Consultee Comments for Planning Application 17588/24

Application Number: 17588/24

Address: 27 Ashby Close Farnworth Bolton BL4 7TS

Proposal: ERECTION OF A TWO STOREY SIDE EXTENSION TOGETHER WITH A PART SINGLE STOREY/PART TWO STOREY REAR EXTENSION.

Drawing:
**00 Site Location
- REV D**

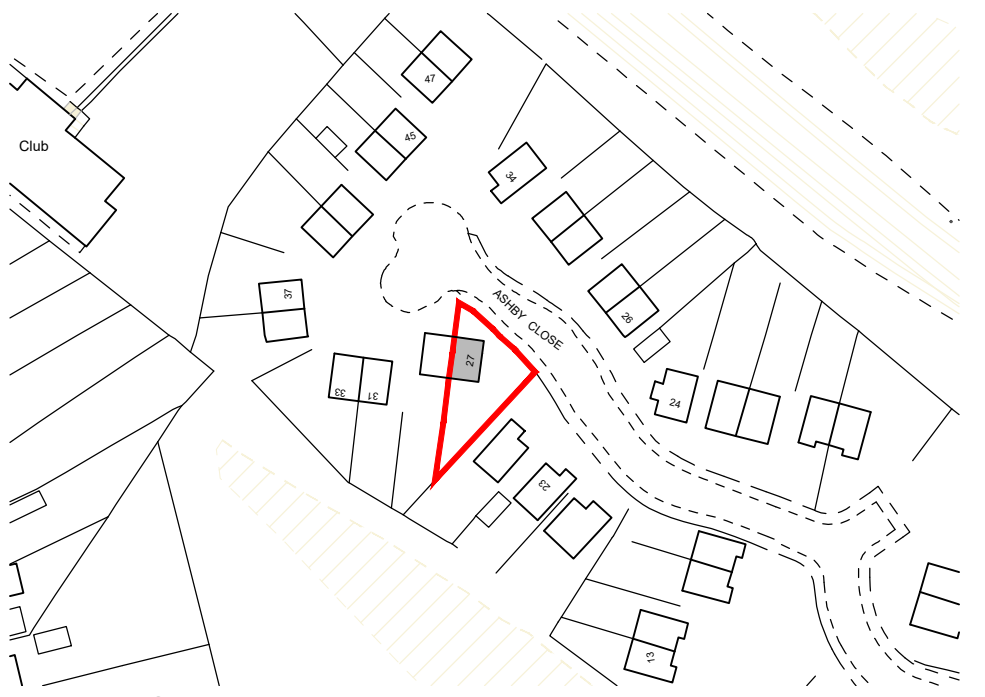
There does not appear to be any off-road parking provision associated with the property. The proposal will convert the house according to the submitted information from a 2 to a 4-bedroom dwelling. The potential increase in on-street parking demand at that location will be minimal and should be accommodated with little additional detriment or severity to residential amenity. Acting on the above comments/observations, the Local Highway Authority cannot reasonably object to what is being proposed under this application.
